# PLANNING DEPARTMENT February 17, 2010 **DRB Comments**

PROJECT # 1007761

**APPLICATION # 10-70049**

RE: Tract A, Black Arroyo Park

PLAT OF
TRACT A
BLACK ARROYO PARK
 SITUATE WITHIN
PROJECTED SECTION 1
T.11N., R.2E., N.M.P.M.
TOWN OF ALAMEDA LAND GRANT
CITY OF ALBUQUERQUE
BERNALILLO COUNTY, NEW MEXICO
 FEBRUARY, 2010

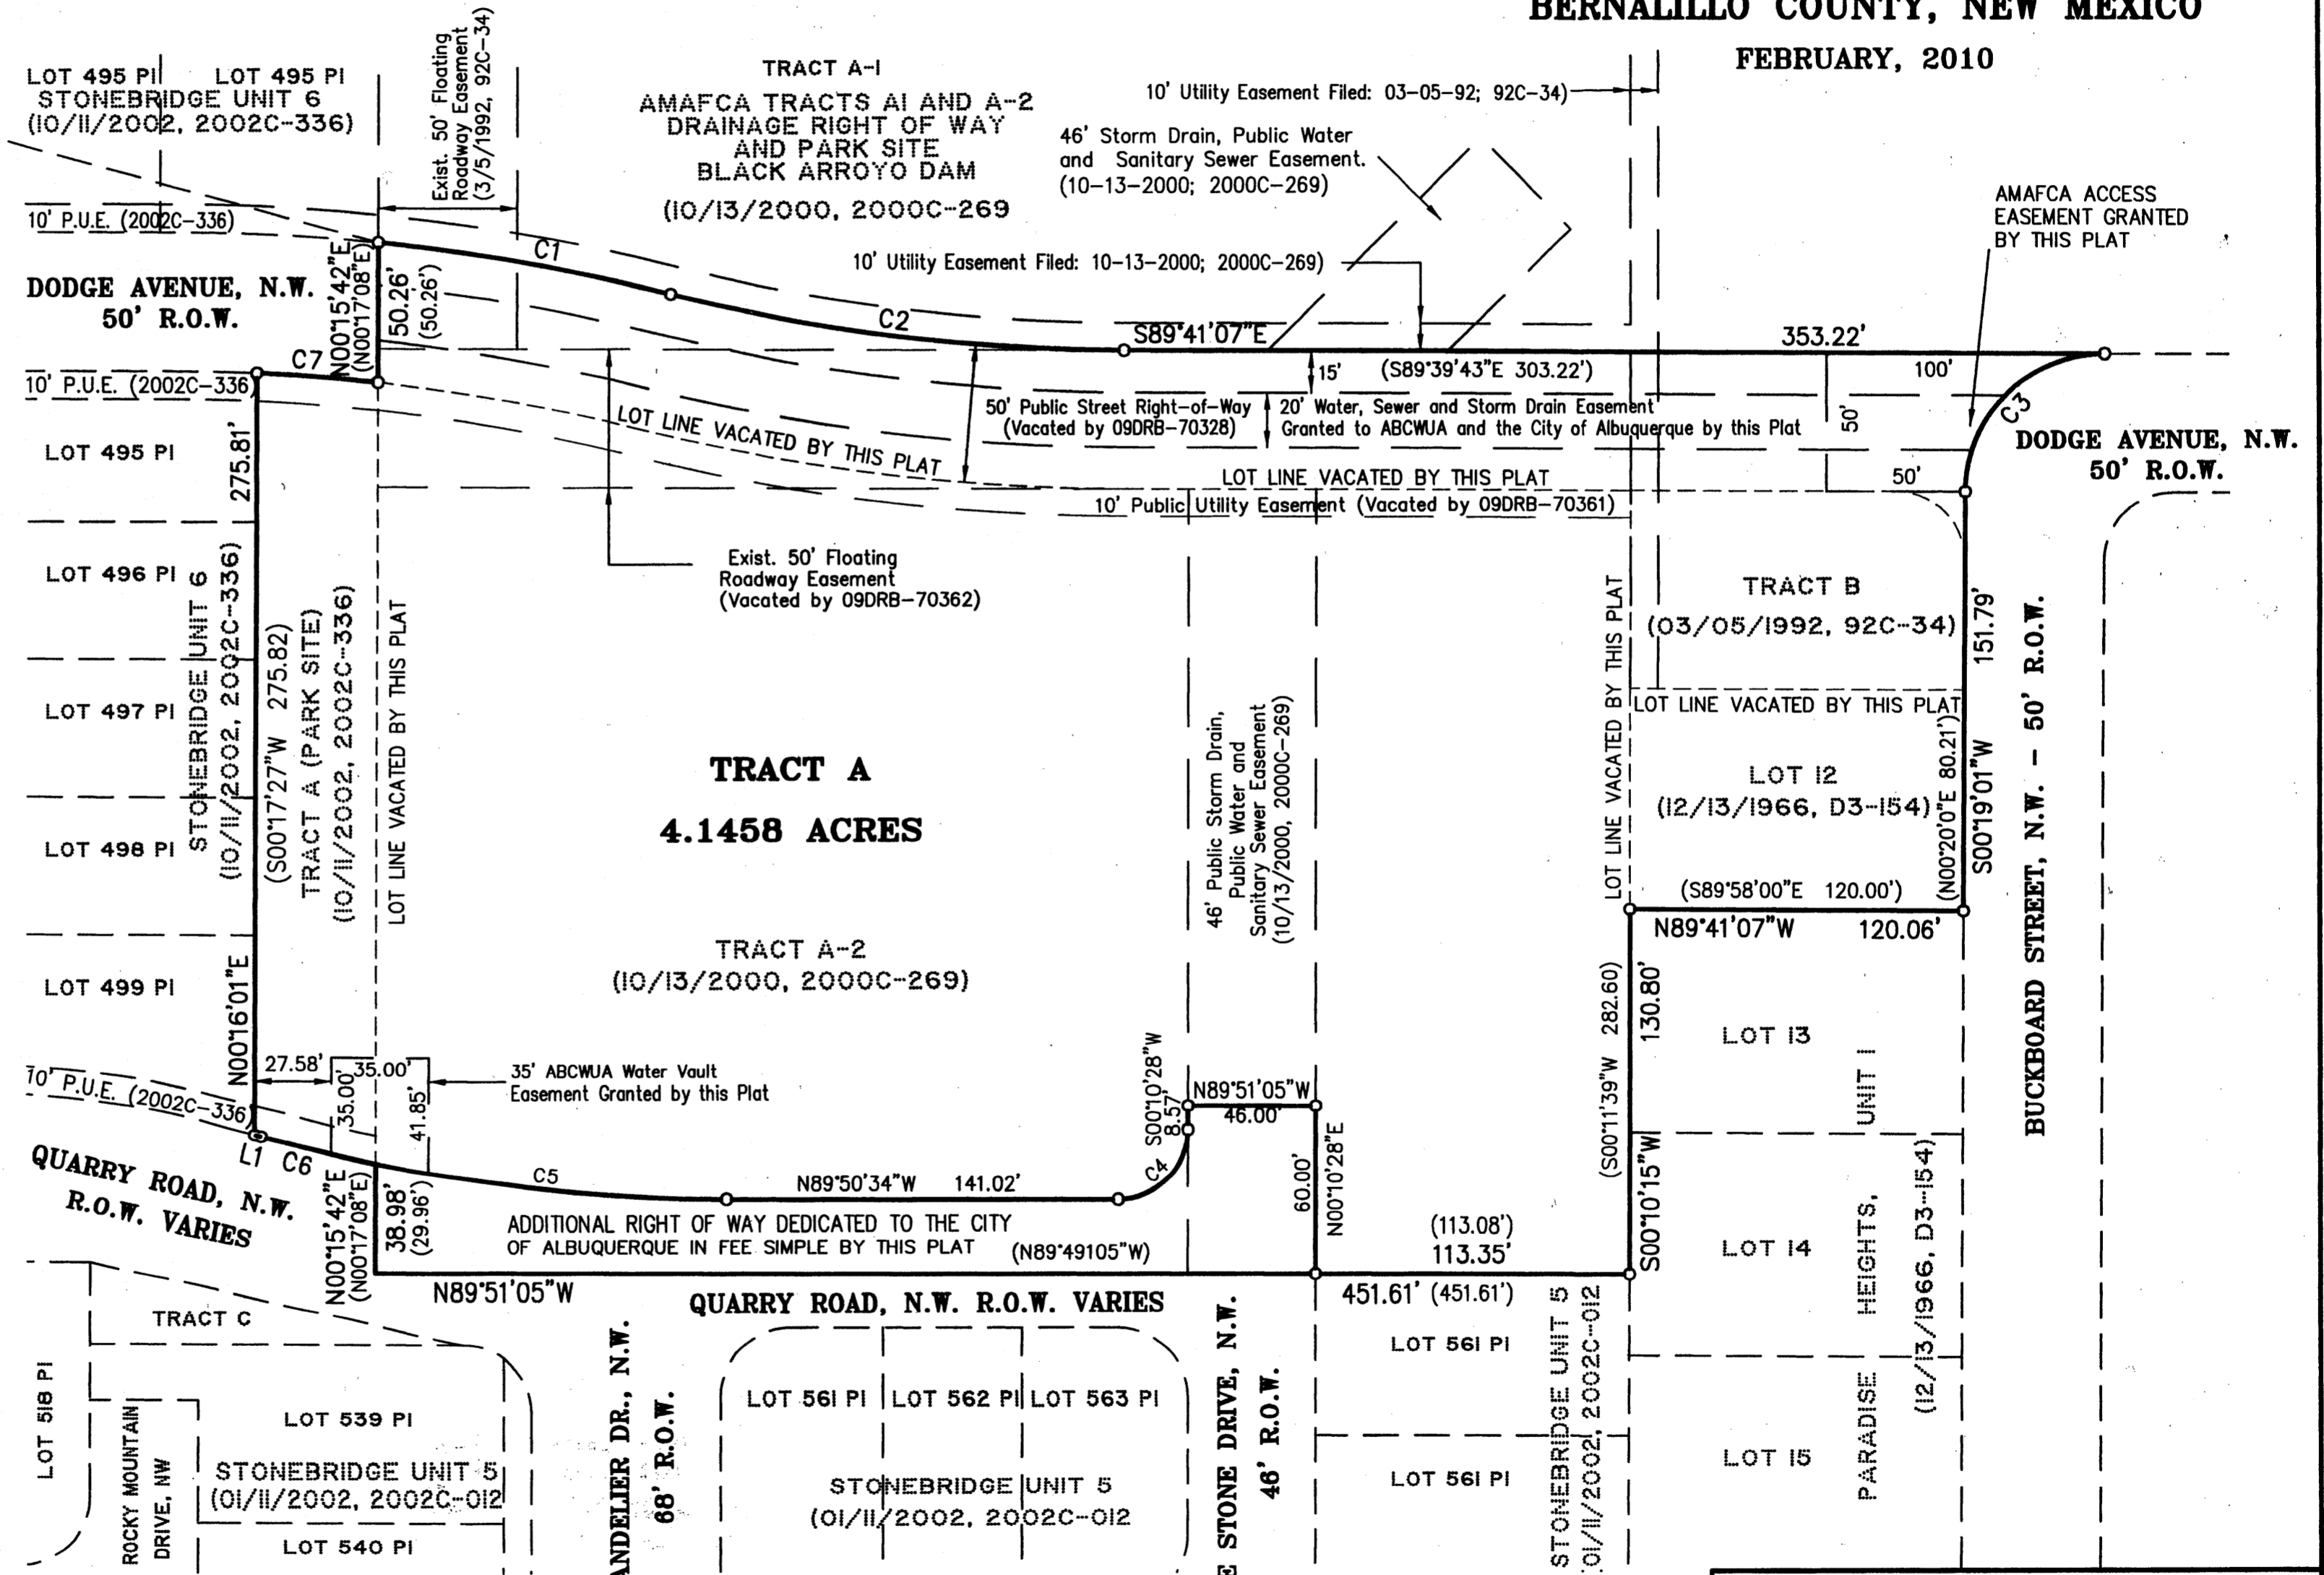
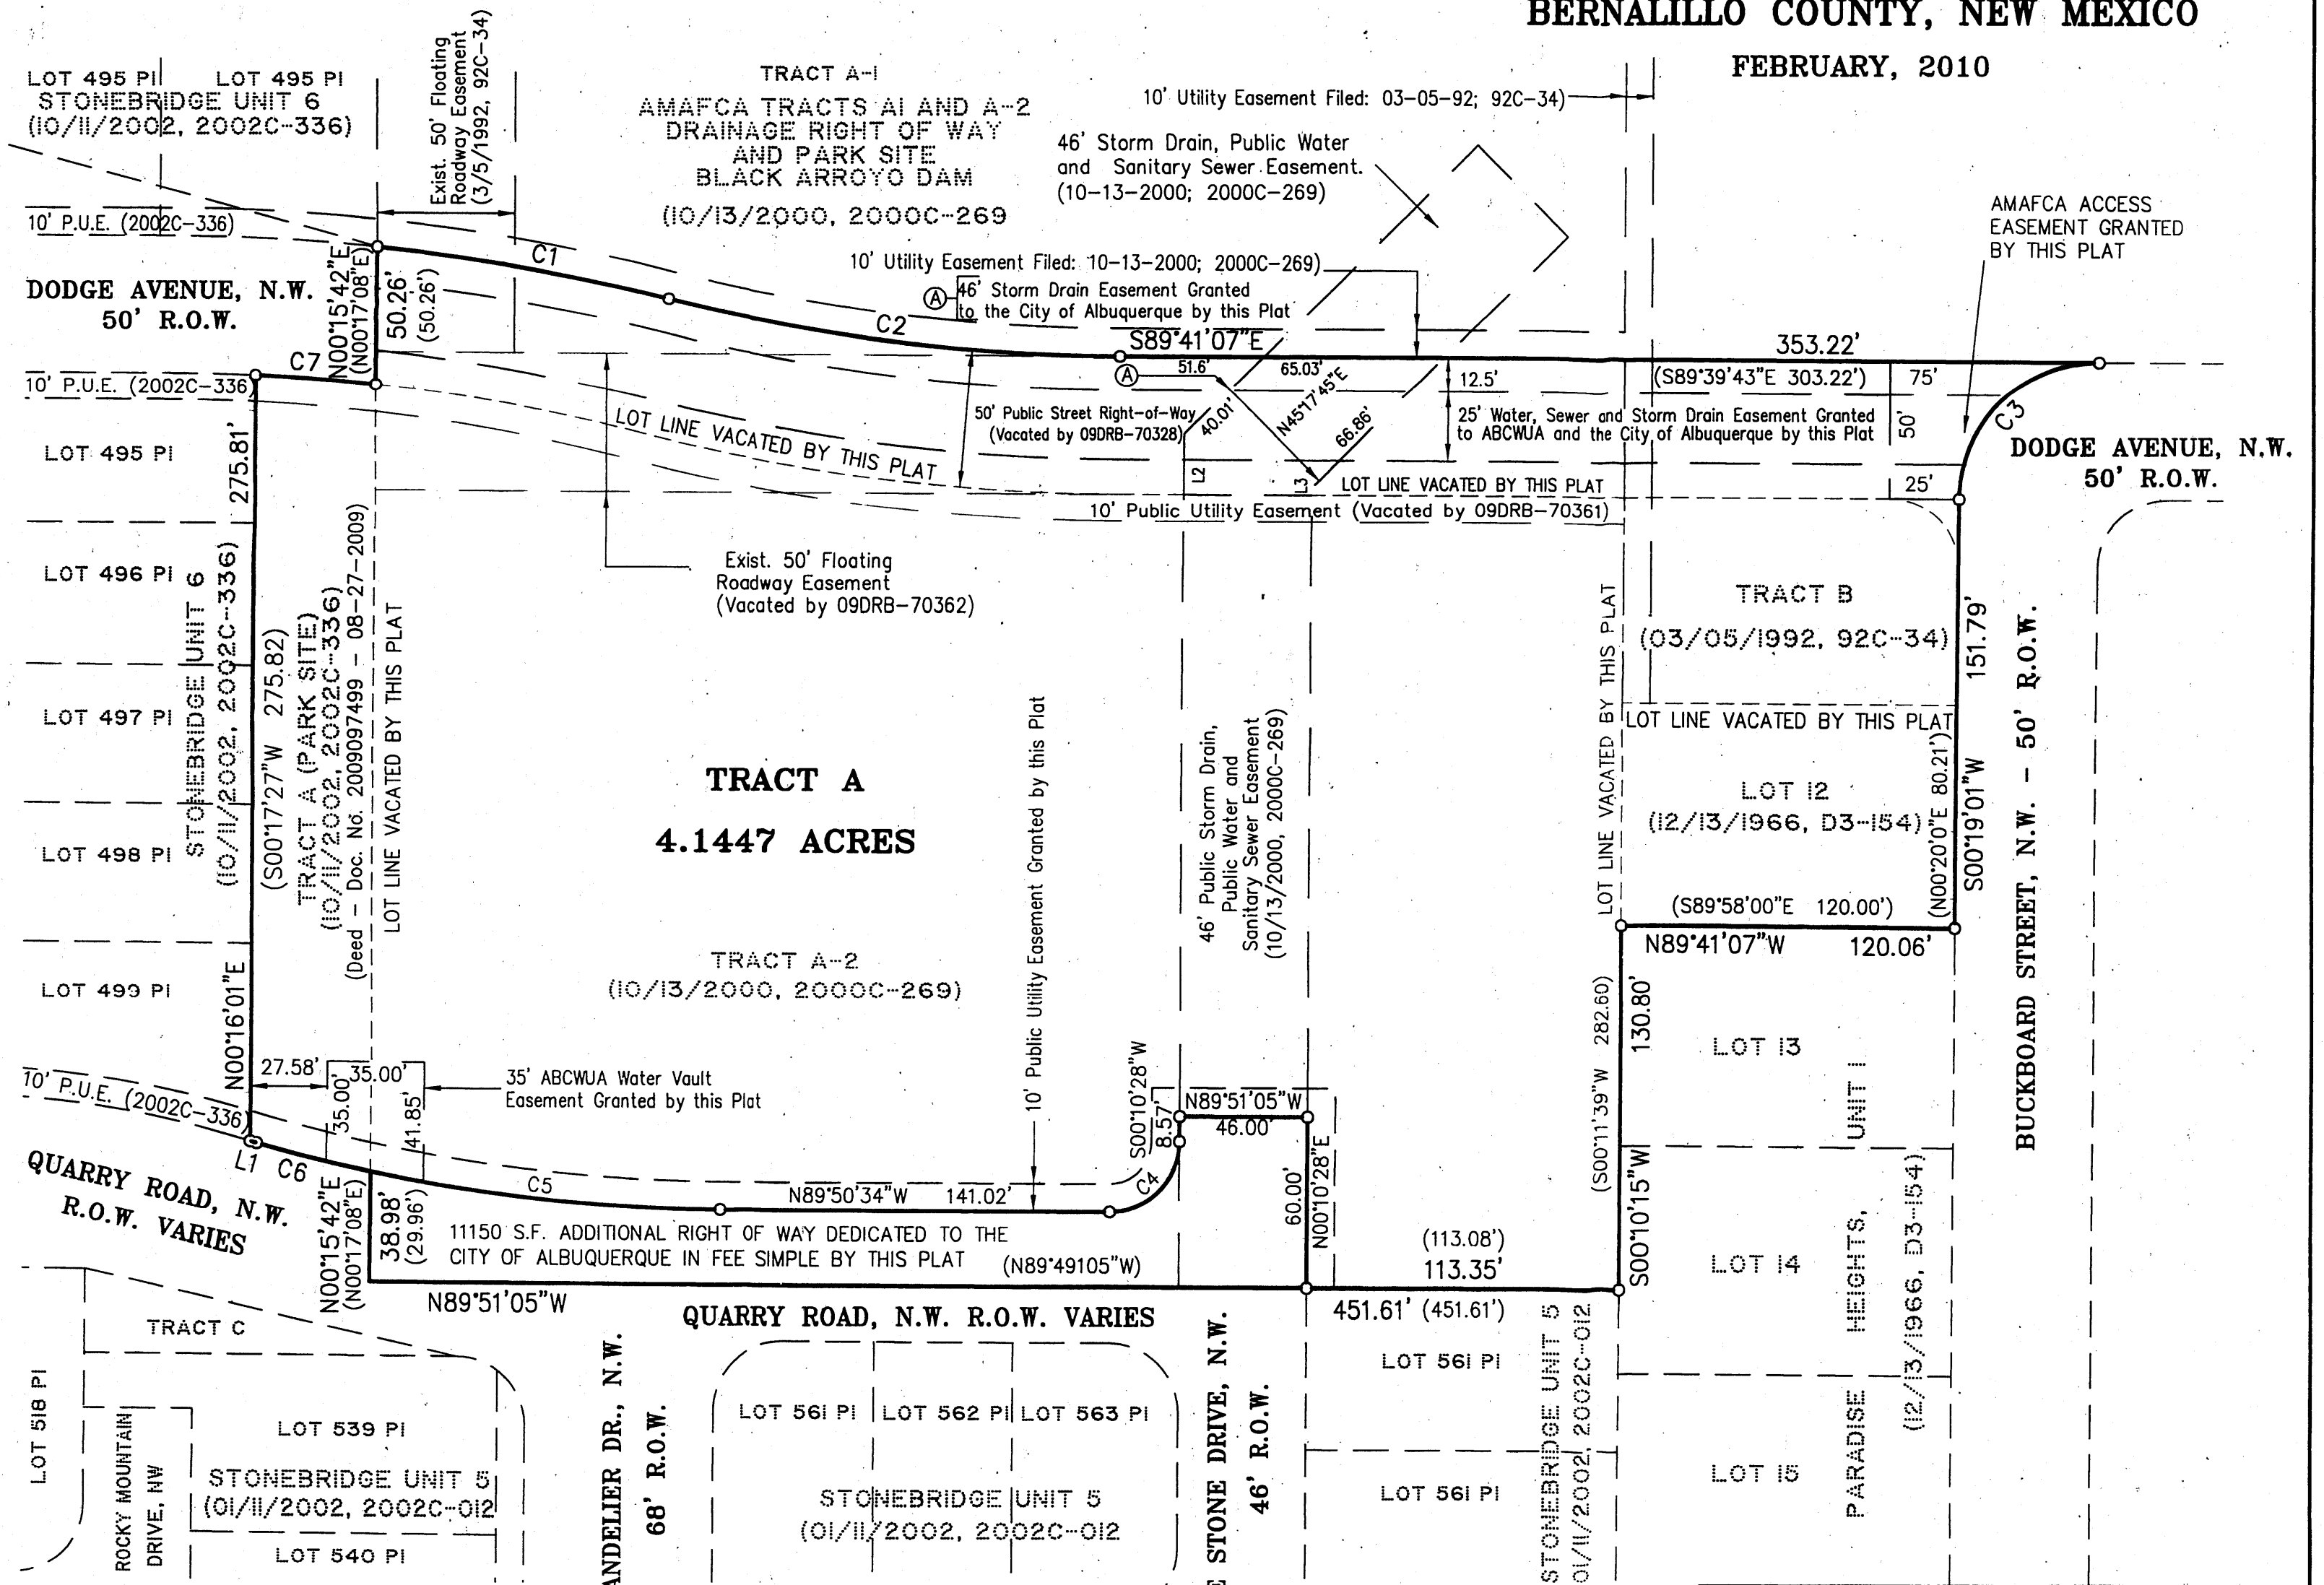
For future reference, please remove zoning note(s) from plat [under NOTES item 5), and under SUBDIVISION DATA, item 8)].
